Engineers Comments Regarding Surface Water Drainage

Application Reference:	FP/79/26/HH	Reviewer Reference:	ADC/EXT5/AF
Planning Officer:	Silvie Steiningerova	Date of Review:	10/07/2026
Site Name:	12 The Crescent Felpham Bognor Regis PO22 7HB		
Application Description:	Removal of existing conservatory and erection of two storey extension including installation of a Juliet balcony.		
Assessment Number:	1

GROUND FLOOR PLAN

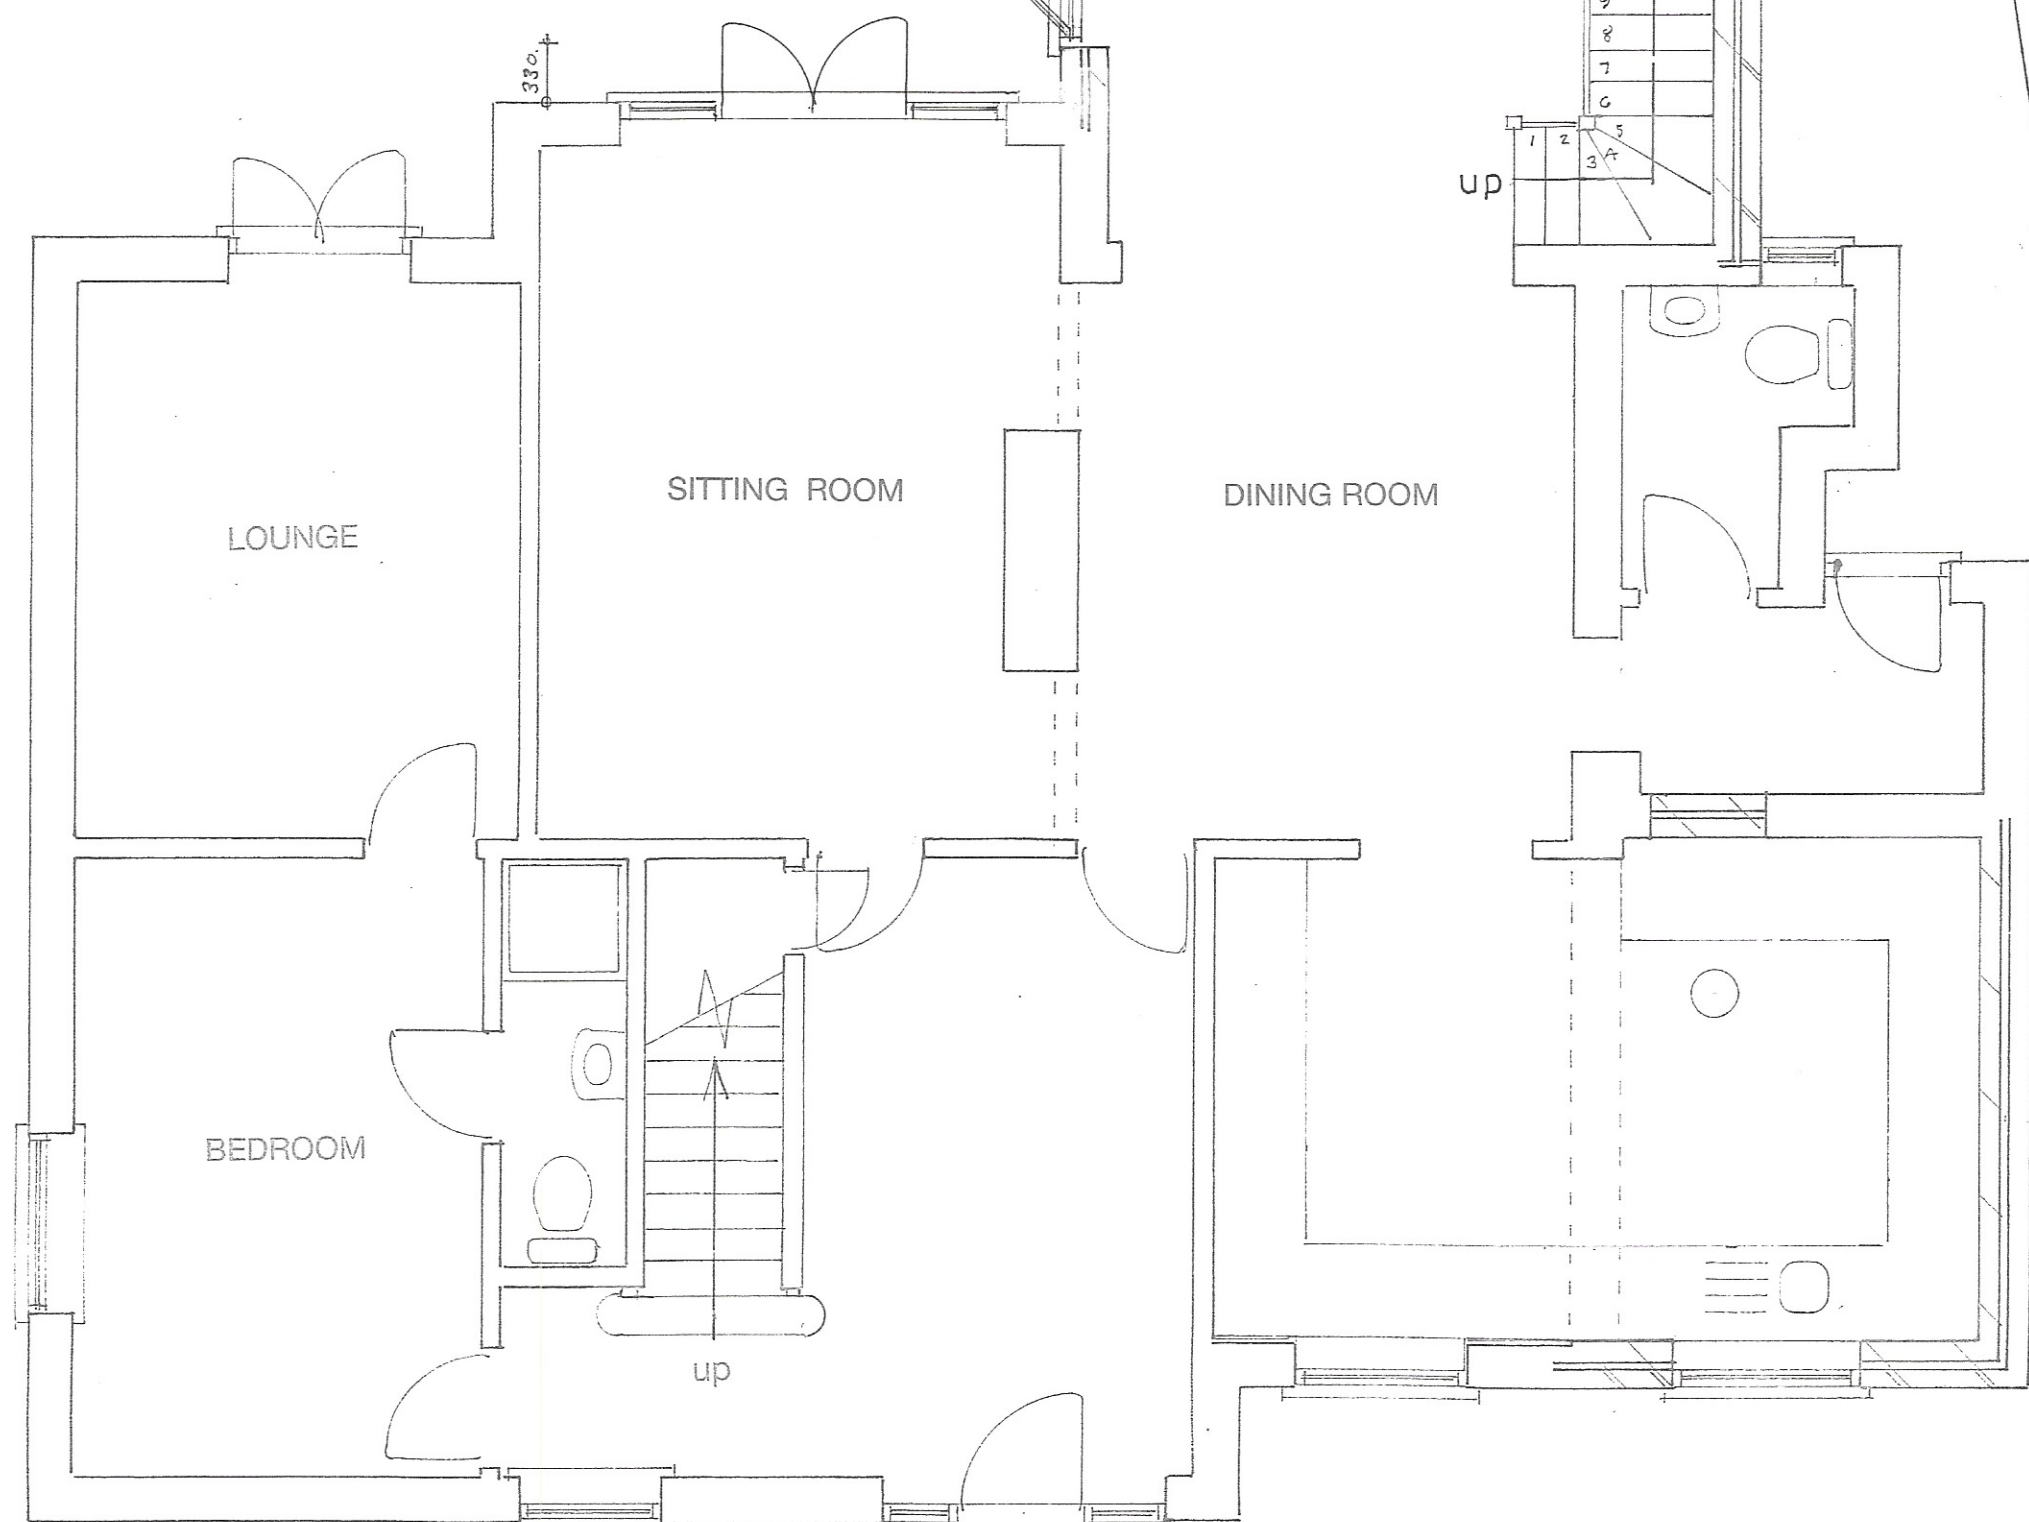
- 1.1. The water reuse priority can be addressed at detailed design stage by providing a residential water butt.
- 1.2. The submitted statement on drainage states that surface water will be discharged to ground via infiltration but no ground investigation is provided to prove feasibility and no other alternative means of disposal is demonstrated to be feasible.
- 1.3. Guidance on ground investigation to support proposals to discharge to ground via infiltration is provided on Arun DC web pages here: <https://www.arun.gov.uk/surfacewater>.
- 1.4. The runoff destination is not currently in accordance with the requirements of the NSfS Standard 1. Therefore, we **object** to the application.

- 3.1. The outline calculations provided for the drainage system are not in accordance with sustainable drainage standards. The additional area should be attenuated, or the infiltration feature sized to accommodate large return period storms.
- 3.2. The drained area should be clarified and runoff calculated for the design storm based upon up to date rainfall data. Guidance is provided on ADC webpages - <https://www.arun.gov.uk/surfacewater>.
- 3.3. Management of extreme rainfall is not currently in accordance with the requirements of the NSfS Standard 3. Therefore, we **object** to the application.

- 4.1. No assessment for water quality is provided with the application and water quality mitigation is not currently incorporated into the design.
- 4.2. However, there is no new trafficked areas shown on the layout and measures to mitigate runoff from roof areas can be integrated at technical design stage.
